PLANNING AMENDMENT

H14/0752/95

Location: Plot at Money Bridge Lane
West Pinchbeck
Spalding
Lincs

Amendment: Revised brick type to Butteley Sunningdale Mixture

Client
MR E. J. SNEATH
drawing
ELEVATIONS, PLAN
& SECTION

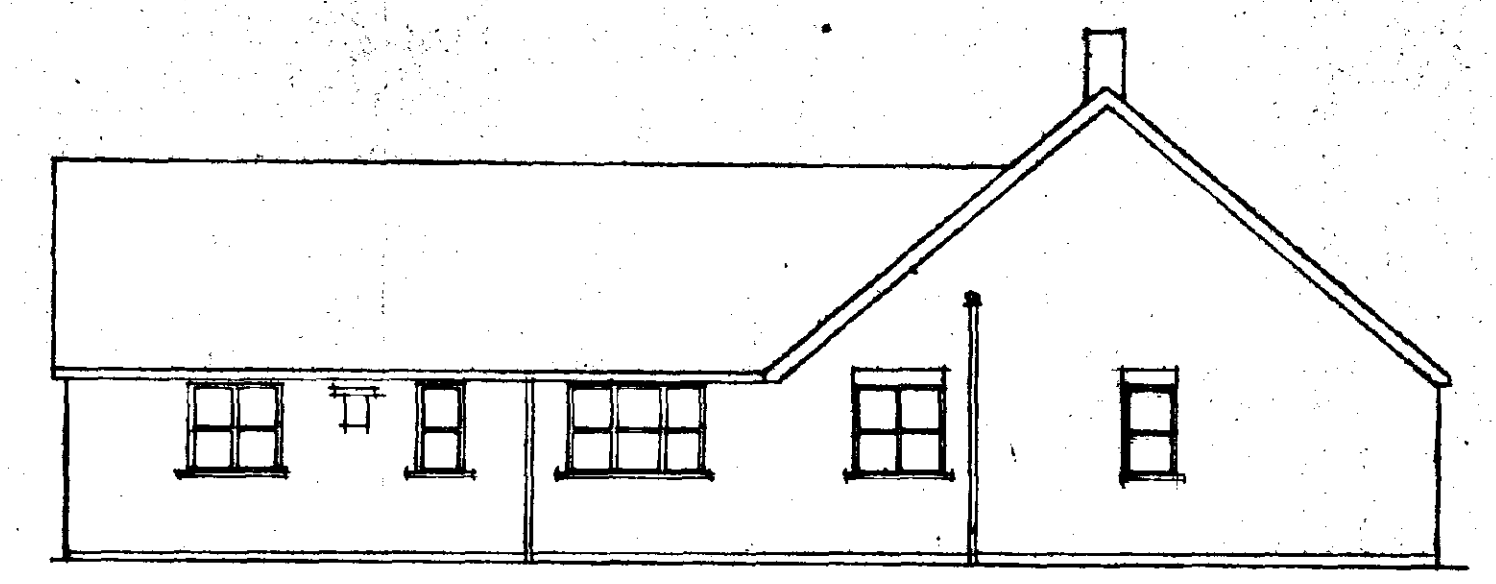
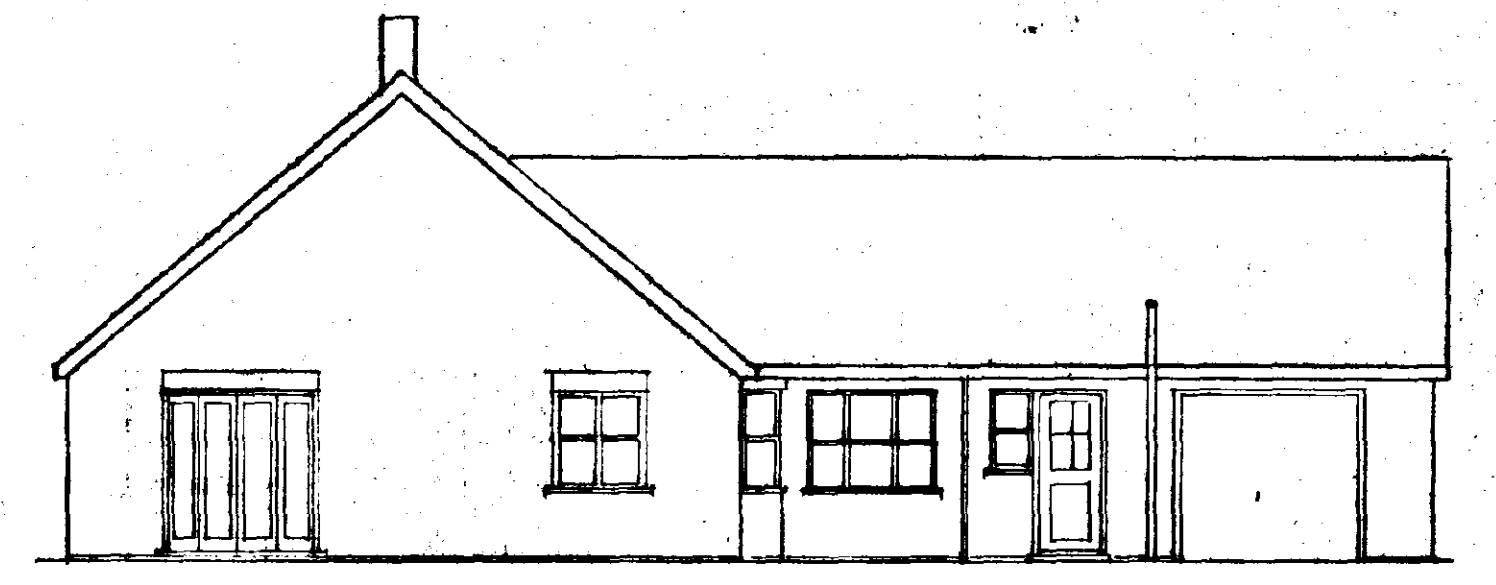
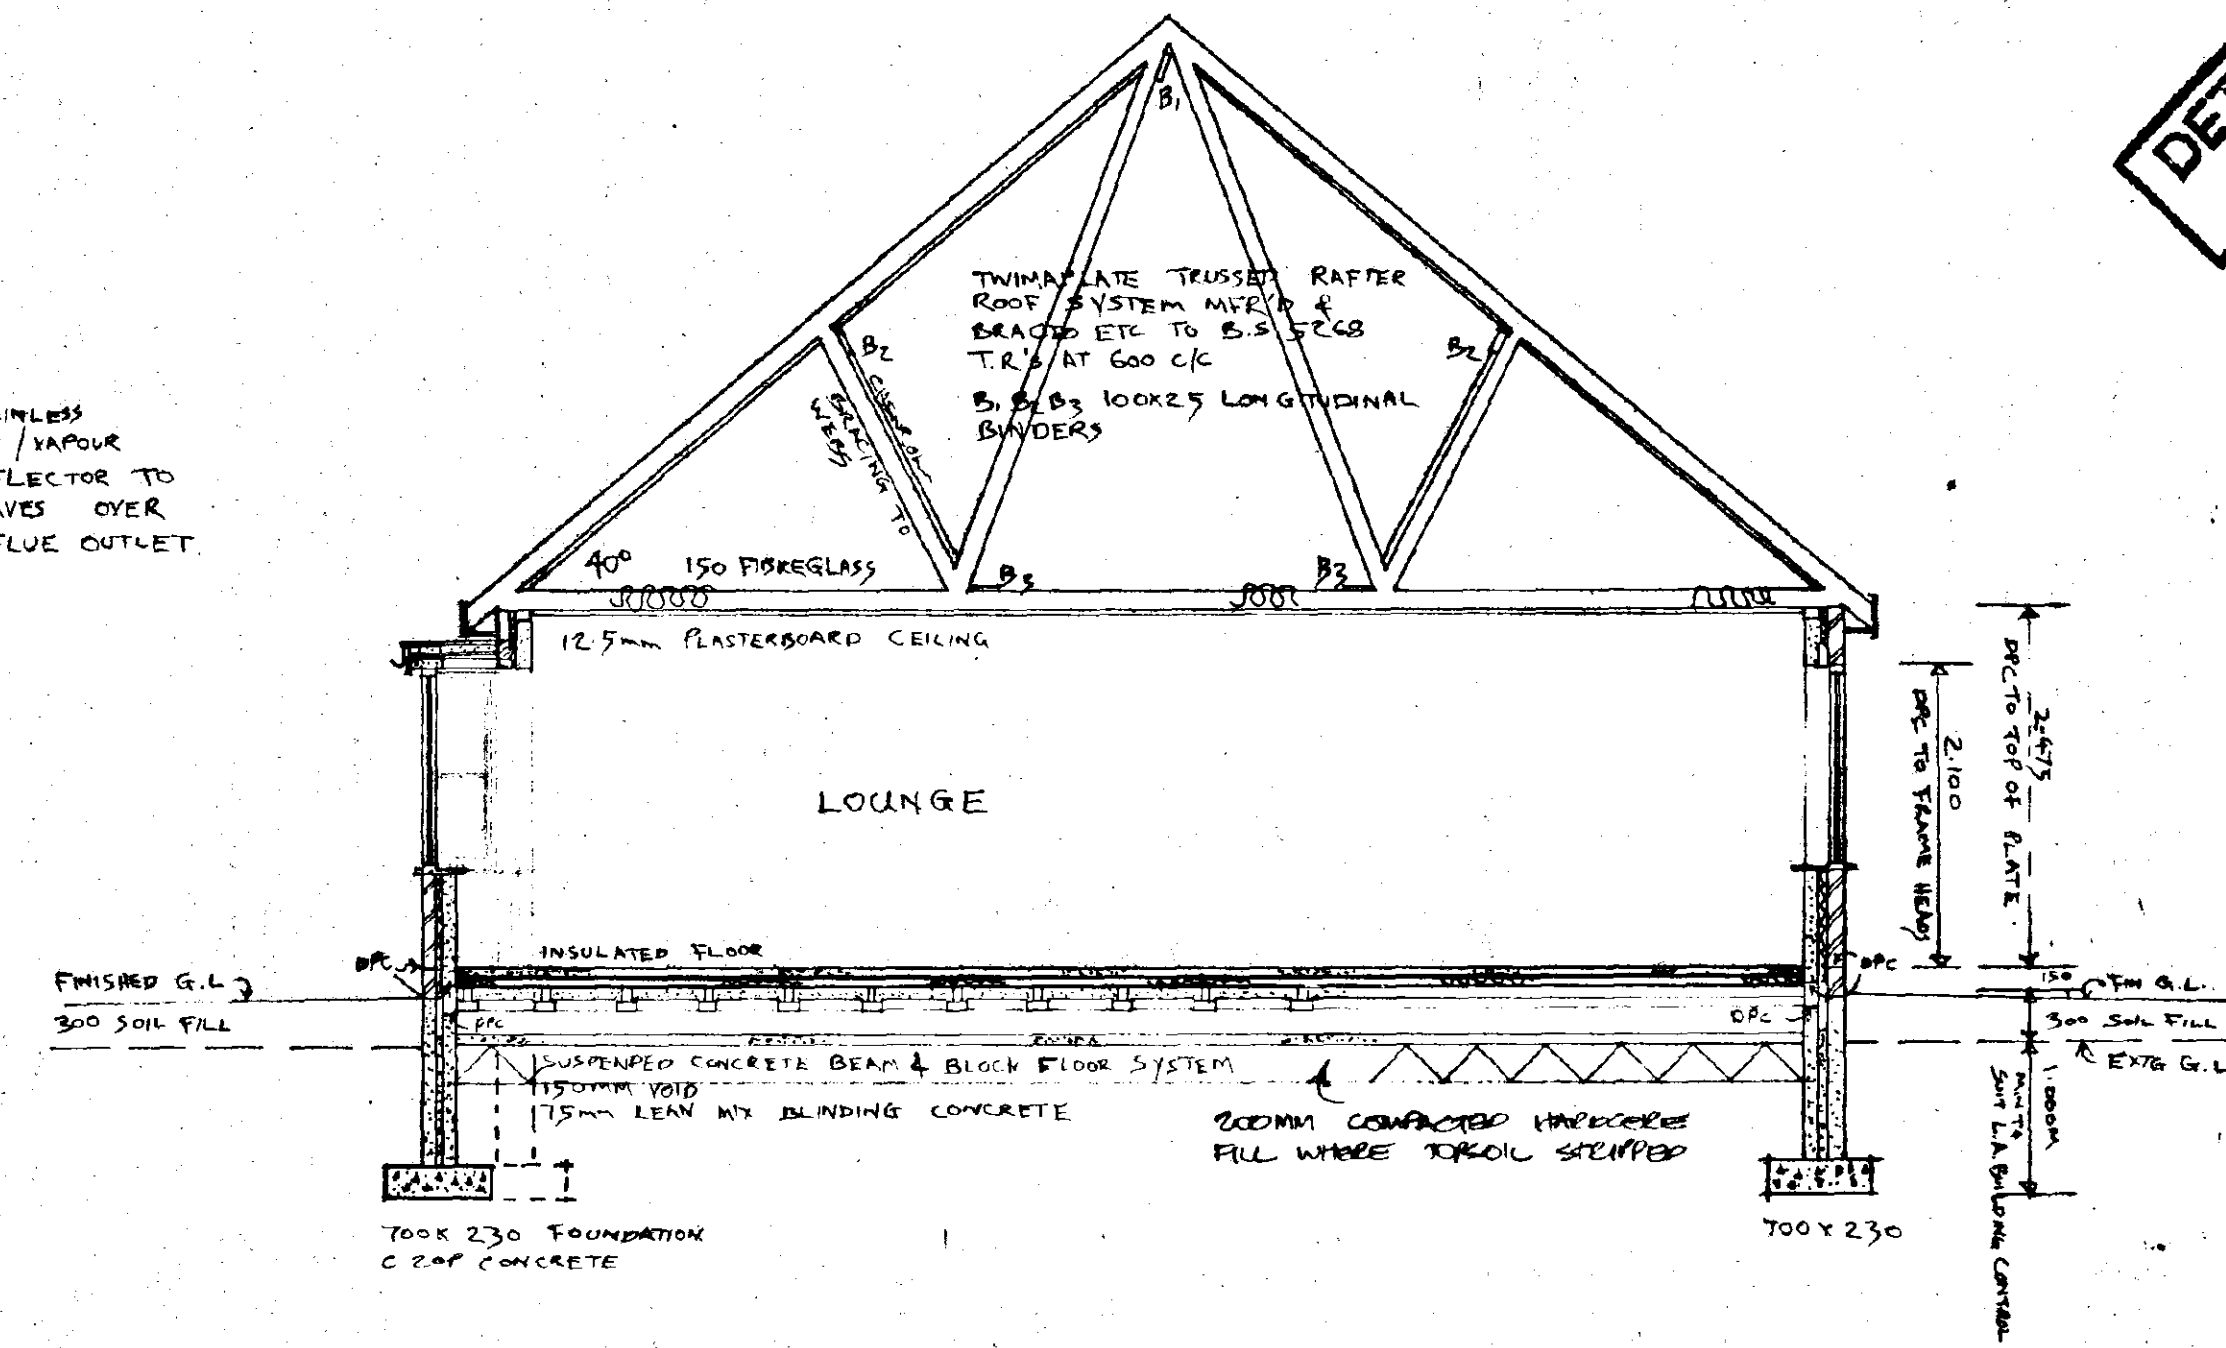
change Brick
to Boffeley
Sunnigdale
mixture

THE BRICKS ON BUILDINGS PERMISSION
ARE NO LONGER AVAILABLE, SO WE HAVE
ENCLOSED A NEW SAMPLE FOR YOU TO TAKE
A LOOK AT AS PER OUR TELEPHONE
CONVERSATION.

The amended details submitted in respect of the above proposal have now been considered and there are no objections to the amendment being implemented to the extent described above.
